**Consultation Response from Alan Smith,
KC Waste Strategy (Refuse & Recycling)**

2025/92139 The Old Dewsbury Library, Wellington Road, Dewsbury, WF13 1HN

**Alterations to former library to form 14 apartments with associated internal and external works
(Listed Building within a Conservation Area)**

Responding Ref: WPN 25 053

PROPOSED BLOCK PLAN
1:500

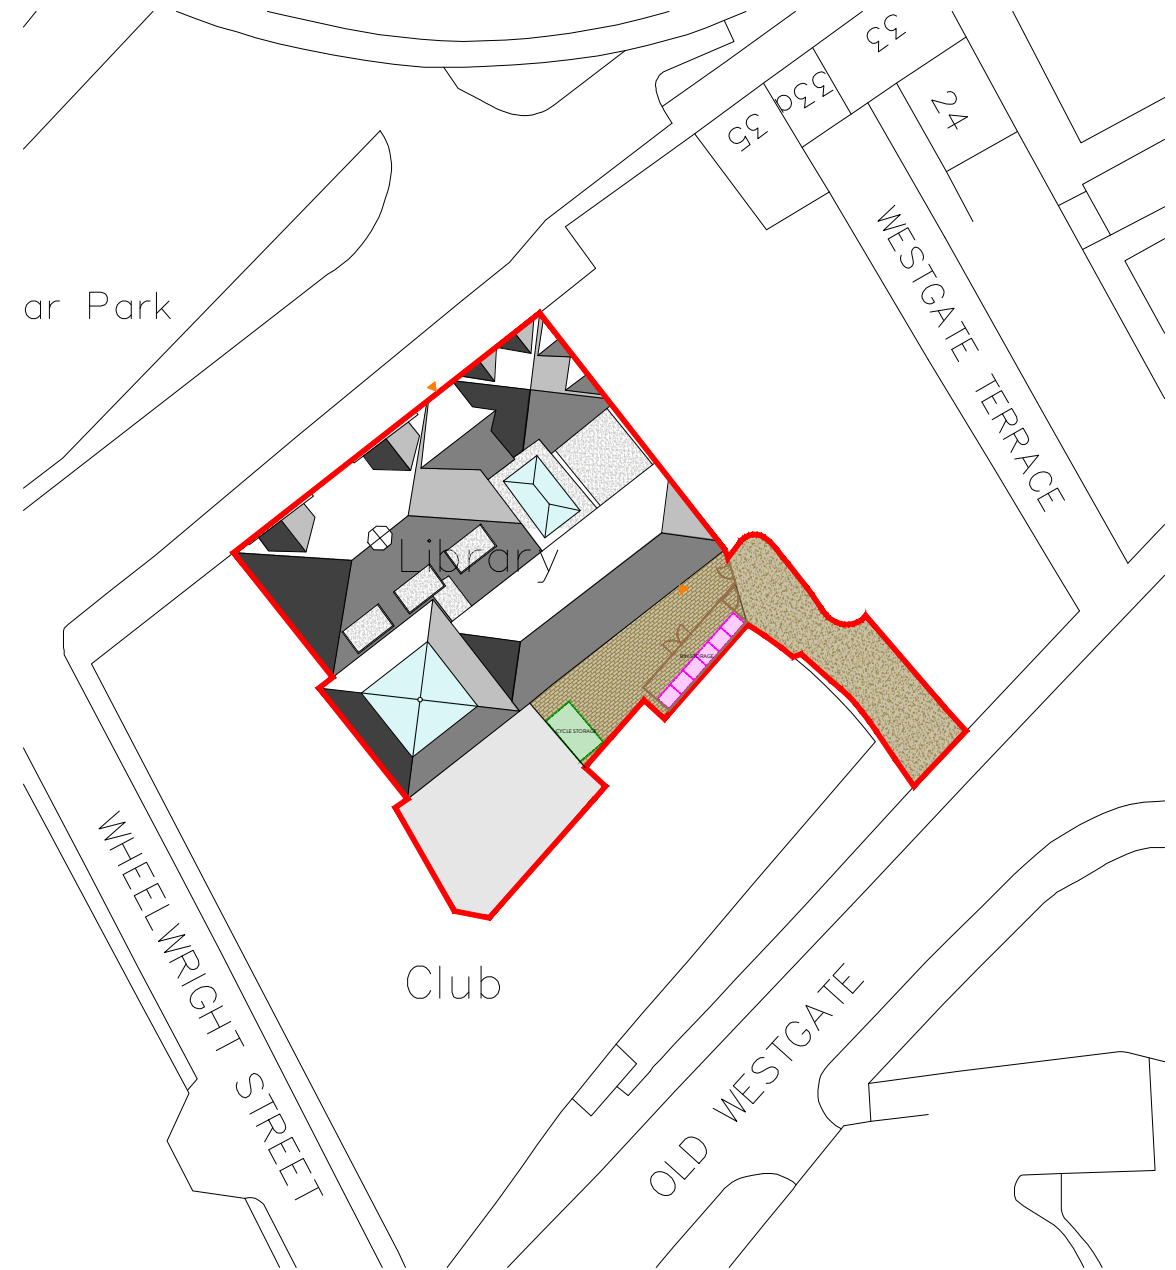
- Due to the location and the slope the proposed collection point is not acceptable to the WCA. The bins need to be placed adjacent to the highway.
- No gradients steeper than 1:12 or steps from storage area to BCP
- Located adjacent to an adoptable highway
- Solid surface required, resistant to constant wear and tear
- The maximum drag out distance from bin storage area to BCP is 25m (BS5906:2005)
